Engineers Comments Regarding Surface Water Drainage

Application Reference:	BN/96/25/PL	Reviewer Reference:	ADC/KW/SB
Planning Officer:	Amber Willard	Date of Review:	
Site Name:	Land West of Brookside, Highground Lane, PO7 4SX		
Application Description:	Demolition of existing barn to be replaced by a new barn within the existing footprint. This application is in CIL zone 3 (zero rated) as other development. This may affect the character and appearance of the Church Lane, Barnham Conservation Area.		
Assessment Number:	1 of 1

Flood Risk Assessment - Proposed Replacement Barn - on Land off Highground Lane, Barnham

PROPOSED PLAN [1:100]

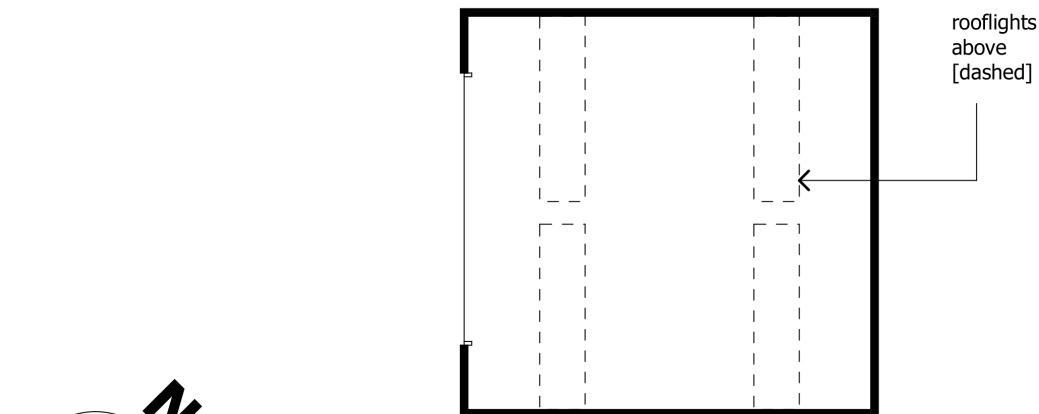
Due to the site's location within the flood plain, further detail of the existing and proposed levels, for both the barn and its access track are requested to ensure that flood risk is not being increased due to changes in levels.

At present insufficient detail has been included on the drainage plans submitted for engineering assessment. In the absence this evidence, and without accurate understanding of the existing site drainage, we cannot assess if flood risk will be increased by the surface water drainage of the proposed development. Therefore, this application does not accord with the NPPF as set out above.

Above: Flood Risk Map - Environment Agency 2025

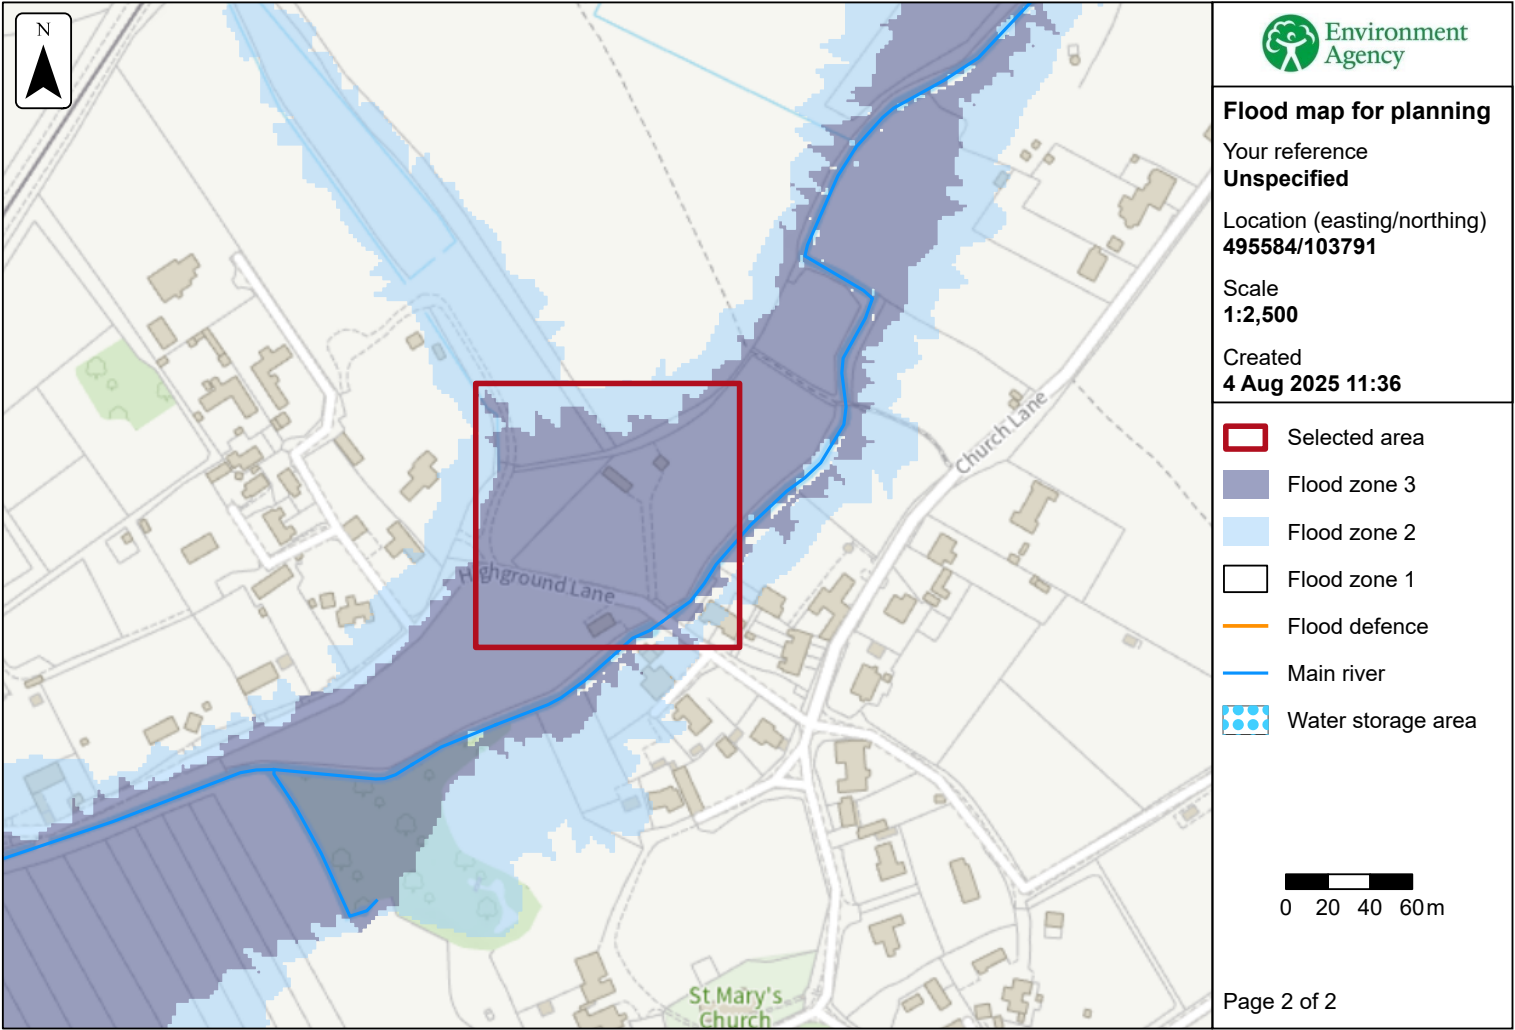
The site is currently located within Flood Risk Zone 3a, indicating a high probability of flooding. Flood Zone 3b is defined as the extent of flooding in the 3.33% AEP event and typically referred to as the functional flood plain. At the time of writing modelling data for this event has not been published to cover this area. The models that are available, are for the 1.3% AEP (less likely) and the 5% AEP (more likely) events. The site is within the extents of the 5% AEP flood event. This is important as there is a risk that the site may be at risk in the 3.33% AEP event and therefore should not be developed unless it is essential infrastructure or water compatible development.

The submitted Flood Risk Assessment (FRA) has not provided robust or accurate hydraulic modelling to demonstrate the site's flood risk during the 3.3% AEP event. It is not supported by product 4 data for the site which can be requested from the Environment Agency. It is important that this information is submitted as it will demonstrate accurately the flood risk on the site and its source. SuDS features should not be located in fluvial flood zones. (Please see our guidance relating to this at www.arun.gov.uk/surfacewater). Without an accurate understanding of the flood risk on the site, we cannot assess if the proposed drainage strategy is compliant. Therefore, I object to the application.

The site is also at high risk of surface water flooding, which is not accounted for by the FRA. This will also need to be considered for the SuDS design for the site.
